ASSESSMENT REPORT

**Global Switch Data Centre
273 Pyrmont Street, ULTIMO
MP 08_0222 MOD 6**

On 16 June 2015, the Proponent lodged a section 75W modification application (MP 08_222 MOD 6) seeking approval for internal and external modifications across Stages 2 and 3 of the approved building (**Figure 2**) as follows:

Lower Ground Facade Lighting

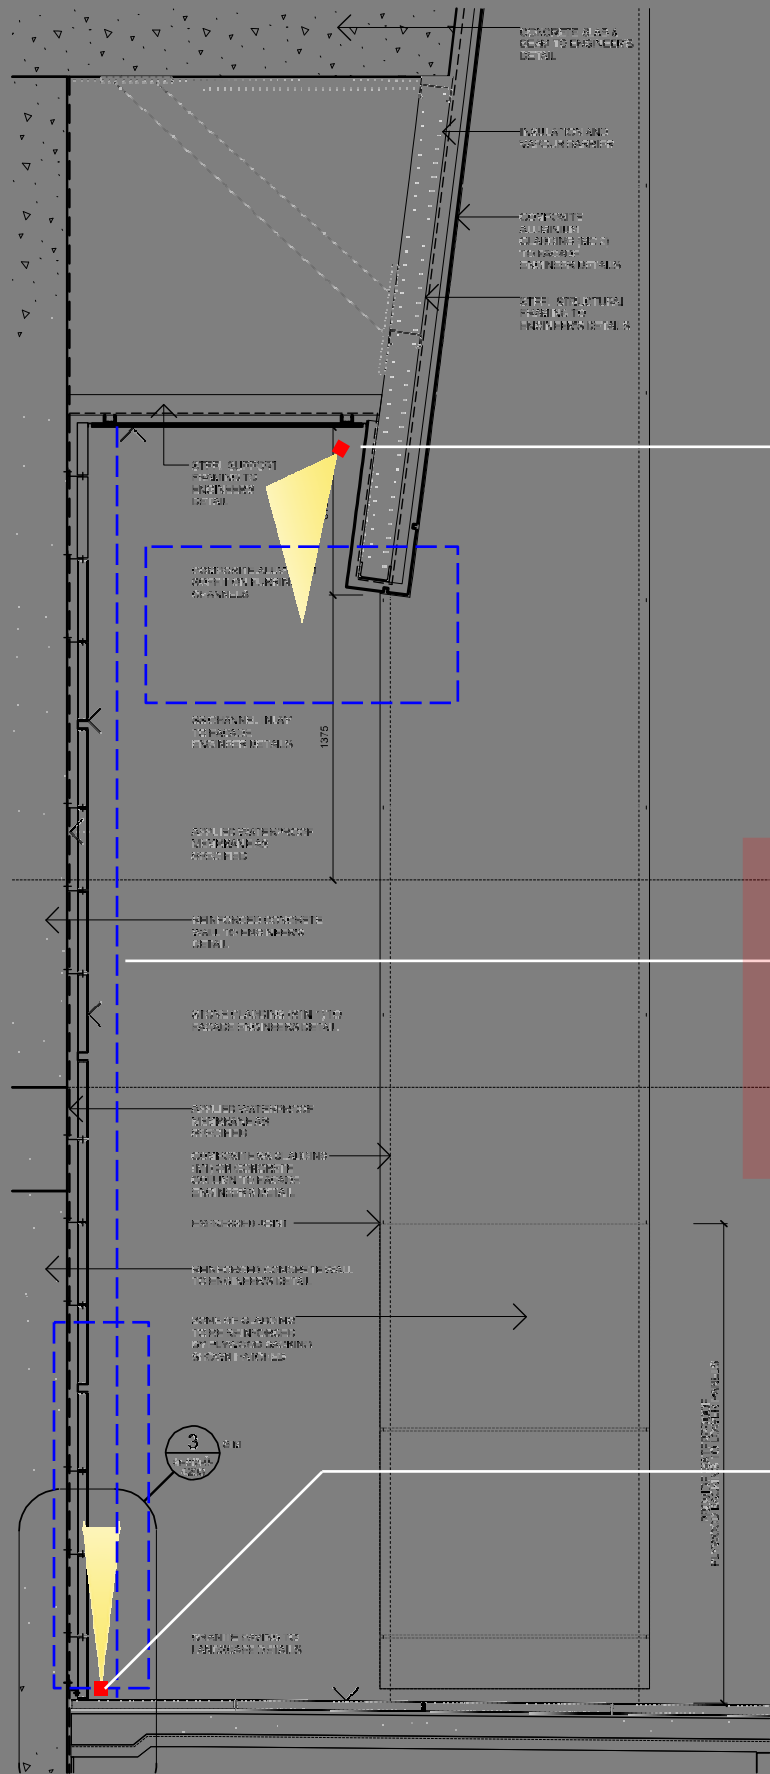
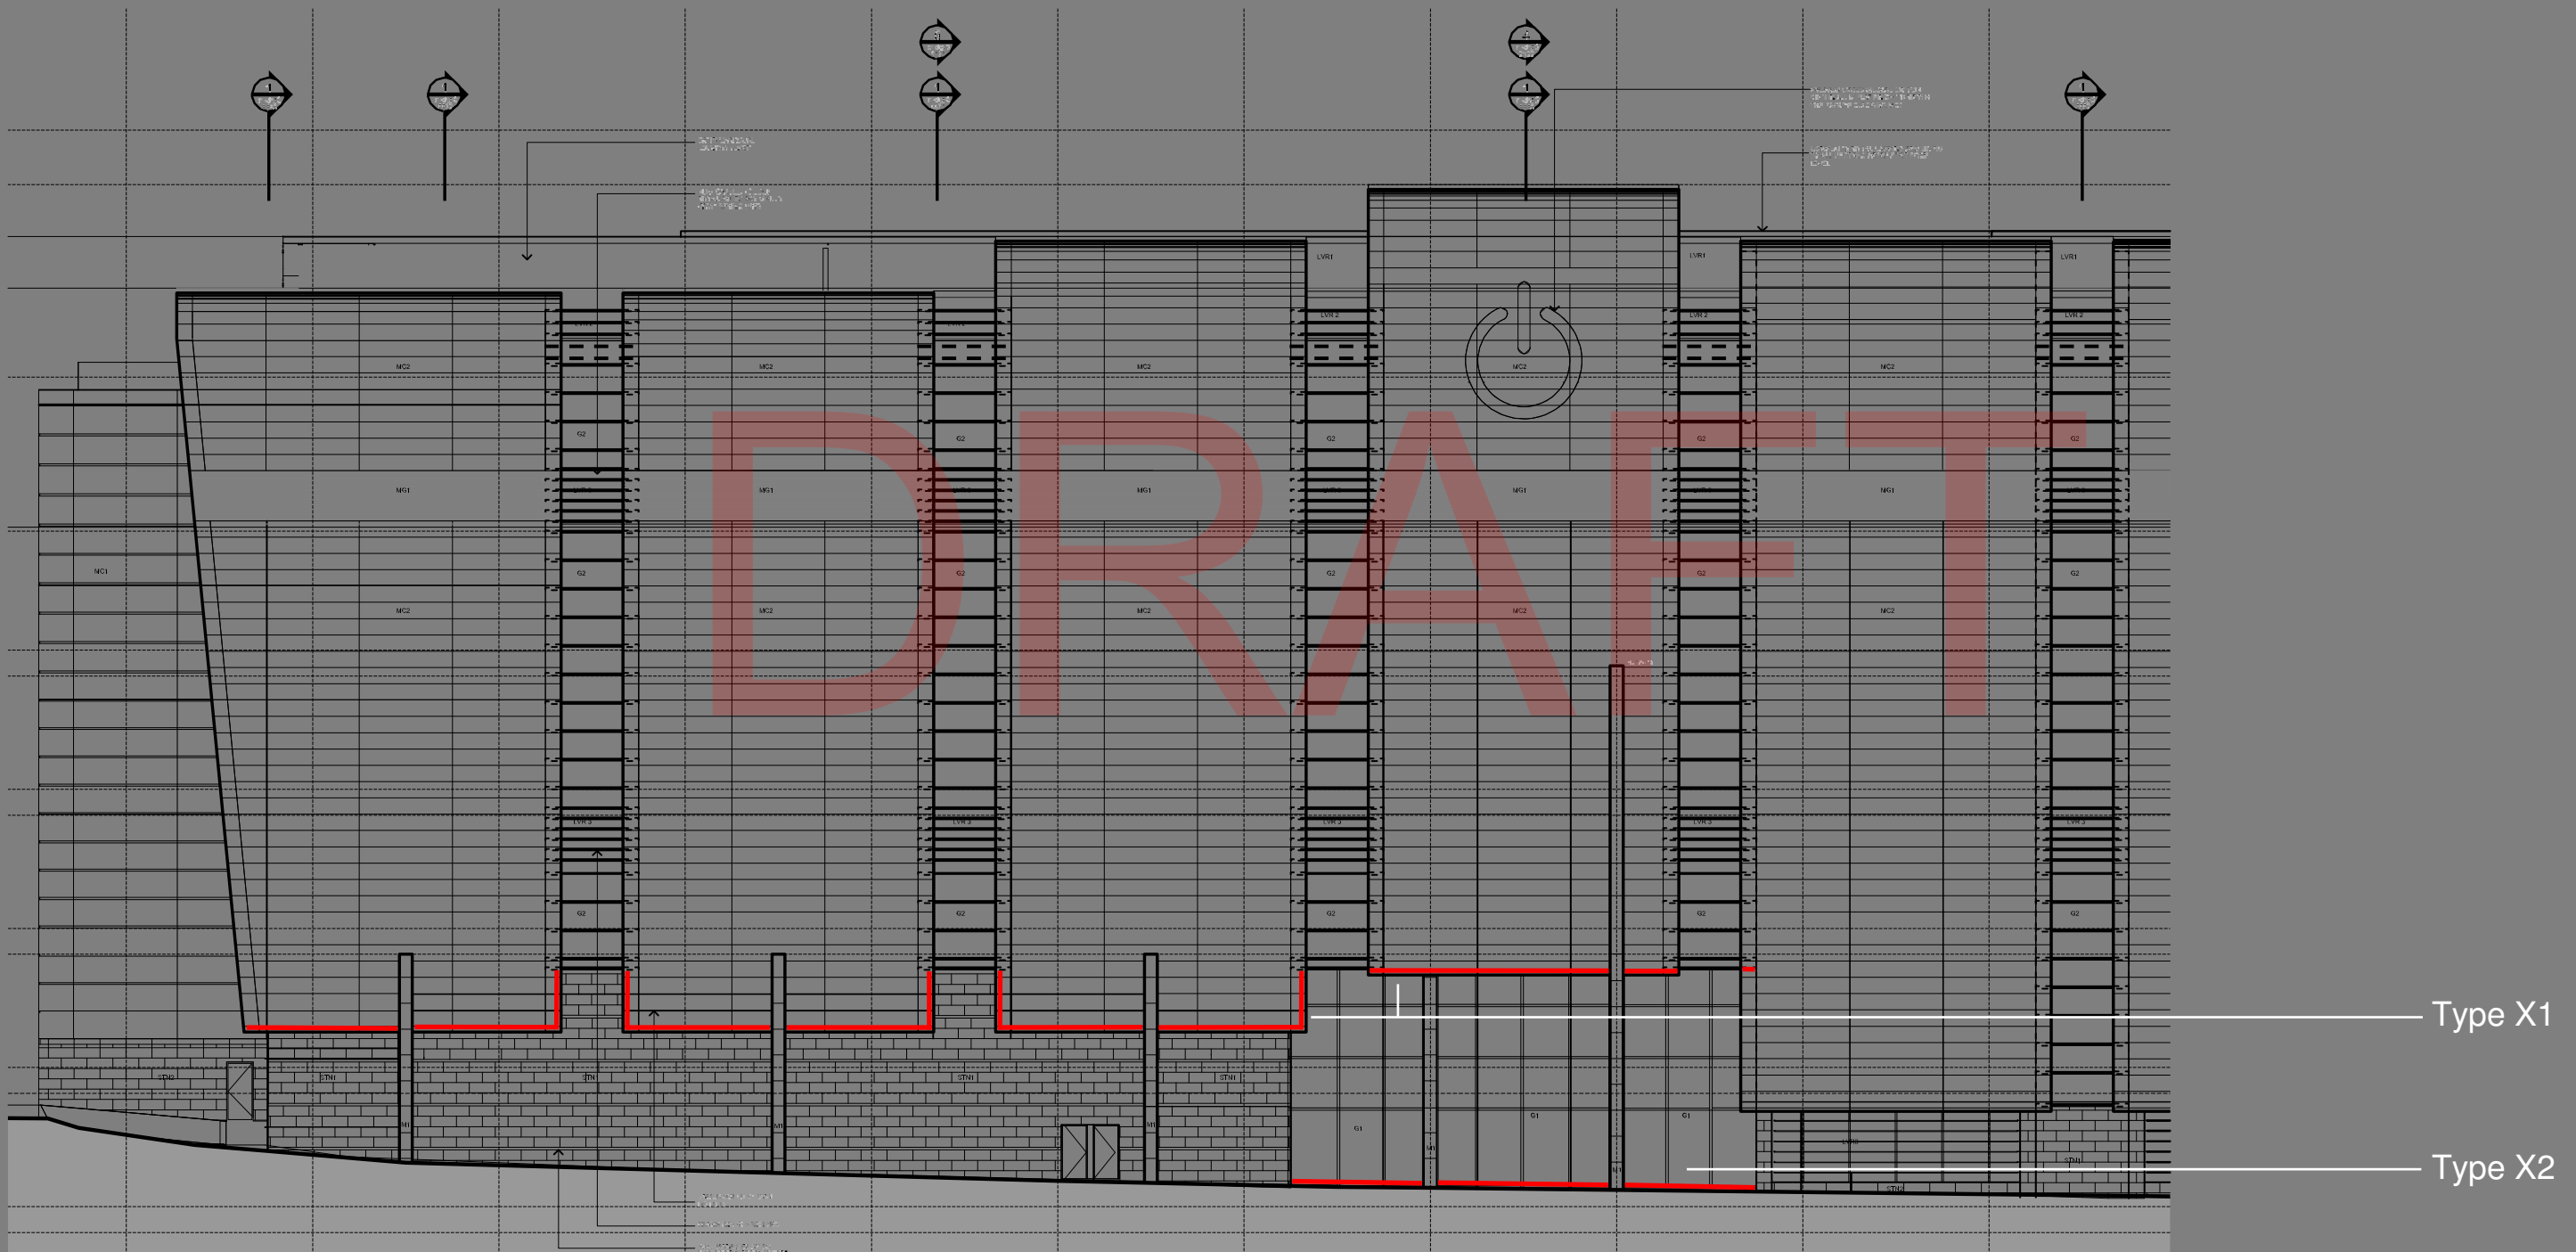
However, to assist with improving visual interest in the façade, sense of activation, and lighting for safety and security, the proponent proposes a high quality external lighting concept for the Pyrmont Street façade (**Figure 4**). The lighting scheme incorporates backlit perforated screen panelling, back lit wall lighting and flood lighting concealed behind the awning canopy.

The proponent advises that the proposed lighting concept would be further developed once a successful contractor for the construction of the building has been engaged, and could be fully resolved prior to the issue of the relevant Construction Certificate. Lighting would be designed to ensure there is no glare to nearby residential properties.

A condition has therefore been recommended, requiring the proponent to submit a detailed design of the Pyrmont Street façade to the Secretary for approval, in consultation with

Council, prior to issue of the relevant Construction Certificate. The alternate design treatment required by the recommended condition should demonstrate:

- successful activation of the streetscape;
- prevention of unacceptable light spill impacts on surrounding residential properties; and
- no adverse traffic safety impacts.

drawing title
East Elevation

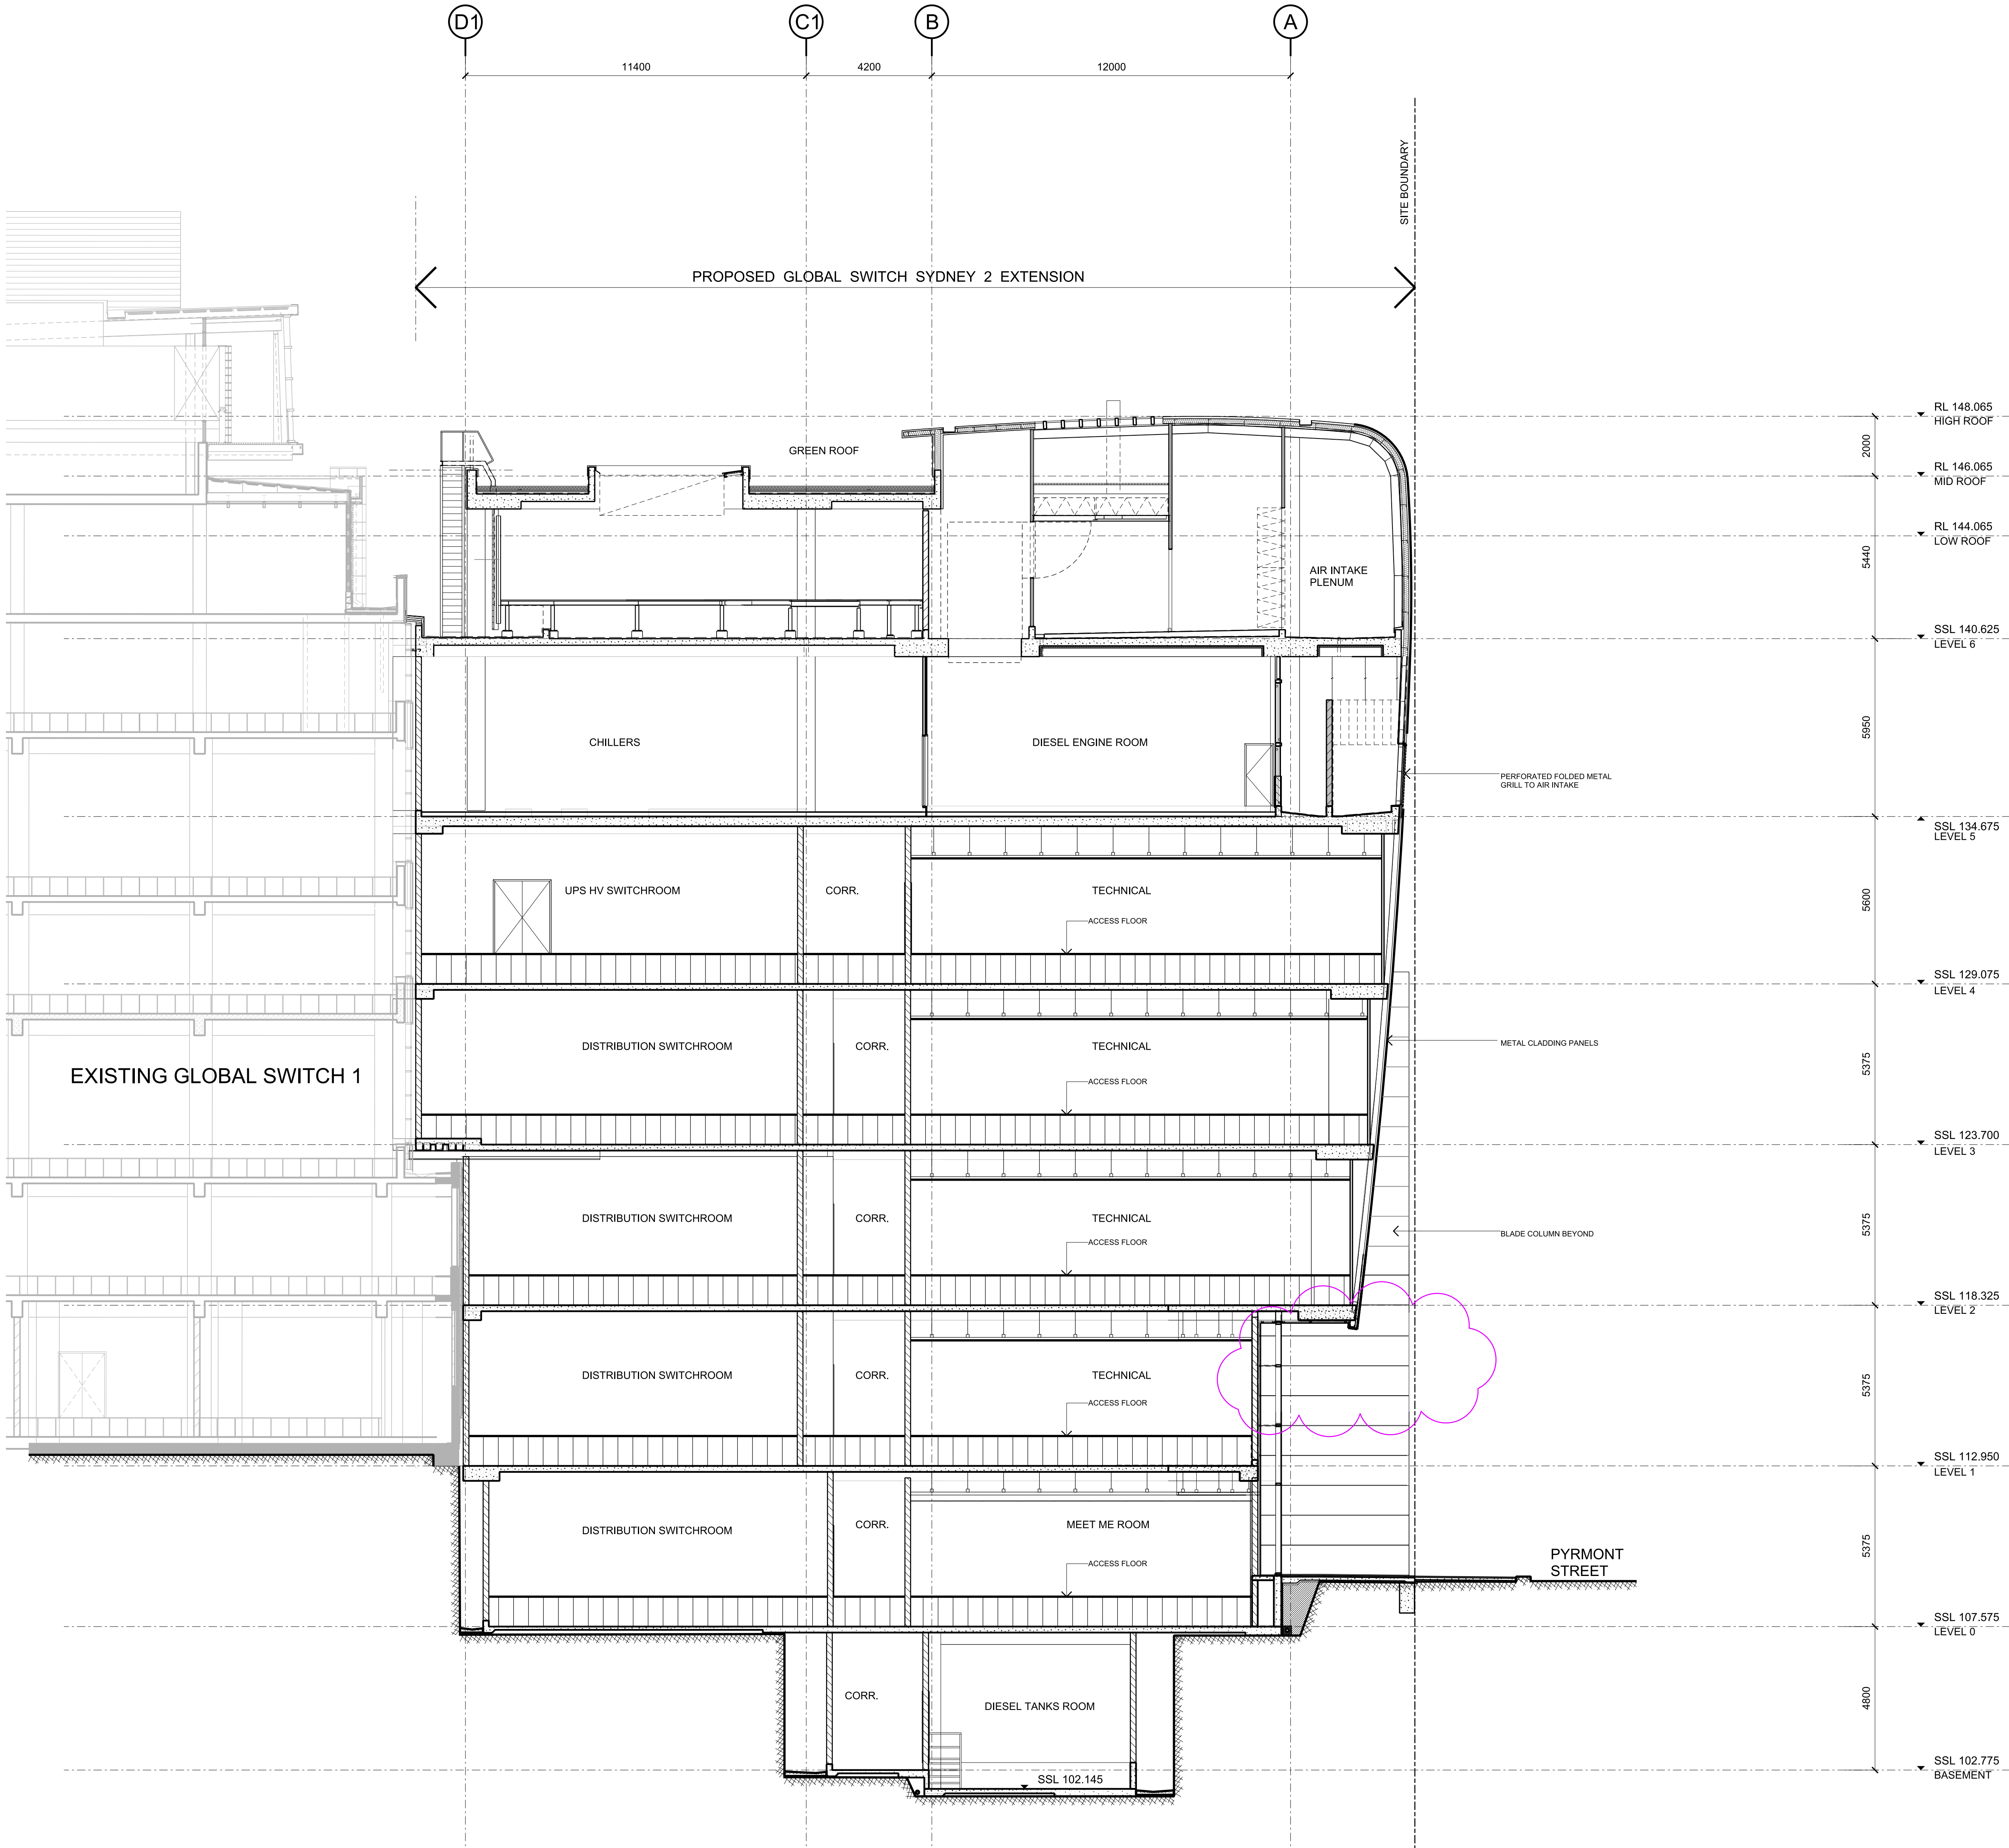
The Department considers the key issue associated with the proposed modification relates to the potential streetscape / urban design impacts due to the proposed deletion of the Pymont Street building entry.

The modification proposes to delete the approved building entry at Pymont Street and to utilise an alternate entry from the adjoining Global Switch Building located on Harris Street. This would integrate both buildings as a combined data storage facility.

Council raised concerns that the deletion of the entry would result in a loss of street activation and suggested opportunities to improve the design for both activation and security purposes should be explored.

Given the unique nature of the building, the Department concludes that the proposed modification to delete the entry and install an alternative façade lighting treatment is acceptable in this case for the following reasons:
